From: Martyn White
Sent: 20 June 2019 09:19
To: Planning.Responses
Cc: Zac Denton
Subject: R/77/19/L

R/77/19/L

The proposal relates to Mayfield Cottage, which is a grade II Listed Building. It is jointly listed with the neighbouring property, No. 49 Sea Lane, Rustington.

The proposal is for a single storey rear extension, which is predominantly glazed. It is intended that there is a mono-pitch roof with two roof lights.

DRAWING
**PROPOSED PLAN
& ELEVATIONS**
DRAWING No
285/03
SCALE
DATE 1:100
REVISION
DRAWN
CHECKED
LA

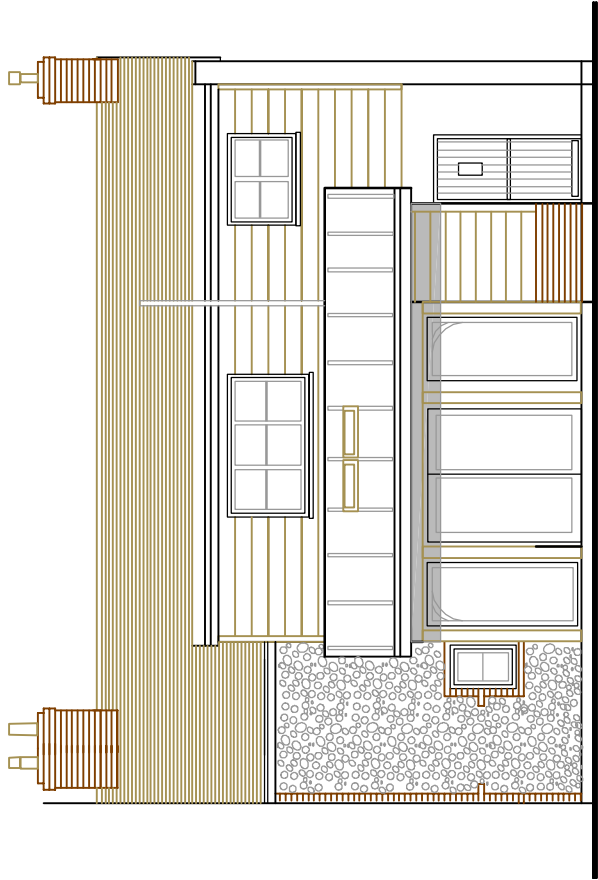
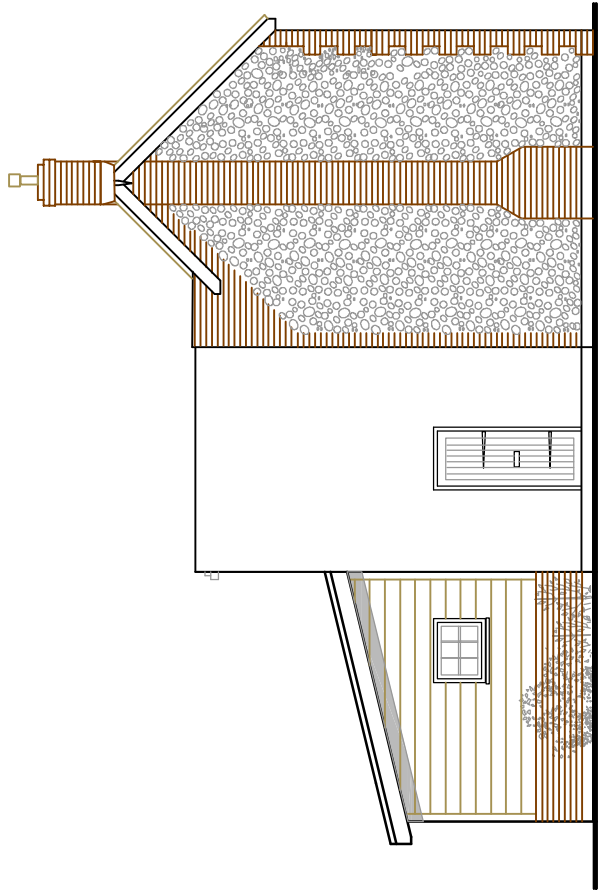
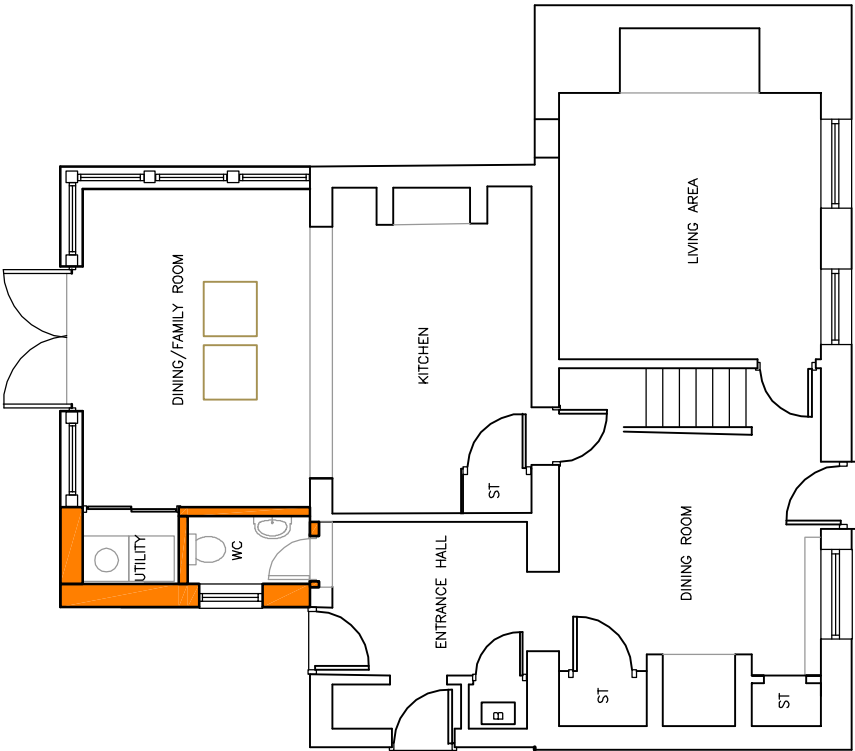
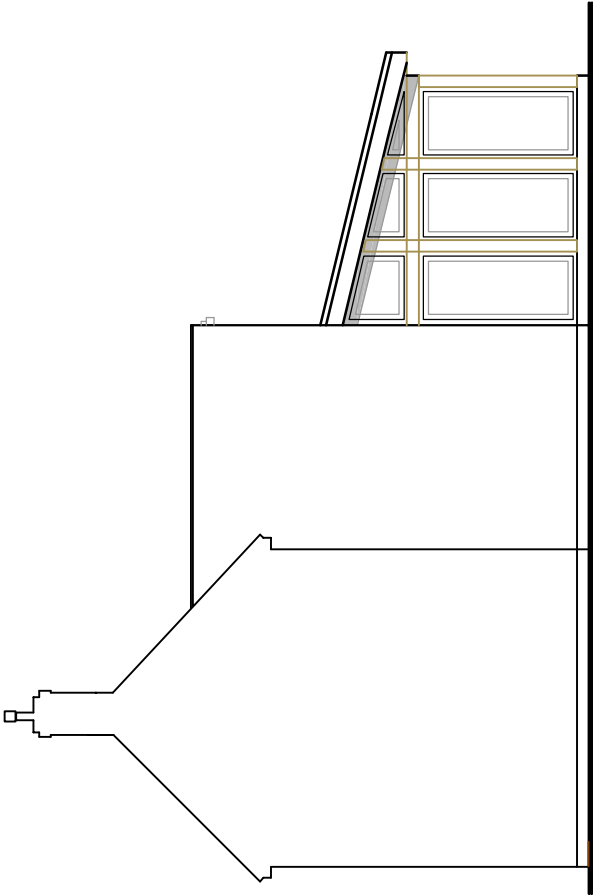
It is considered that the structure appears to be subservient to the host dwelling, and designed so that it will be 'light weight'; that is to say, it won't dominate the rear elevation of the property. However, saying that, it will ensure that it helps to reduce the impact of the 20th century extension which detracts from the character of the building.

I note that it is proposed for a section of the rear wall is to be removed in order to open up the extension to the kitchen. This section of walling relates to the modern, 20th century extension, and as a consequence will not affect any historic fabric. The proposal also provides for a 'nib' of the existing wall to be retained, which allows for the evolution of the building to be understood.

It is also positive to note that appropriate materials are proposed, and that the existing boarding will be replaced with something more in keeping.

If minded to approve, it is suggested that the roof lights should be of conservation standard, and the glazing should be the slimmer units associated with a listed building. You may also wish to condition details of the windows.
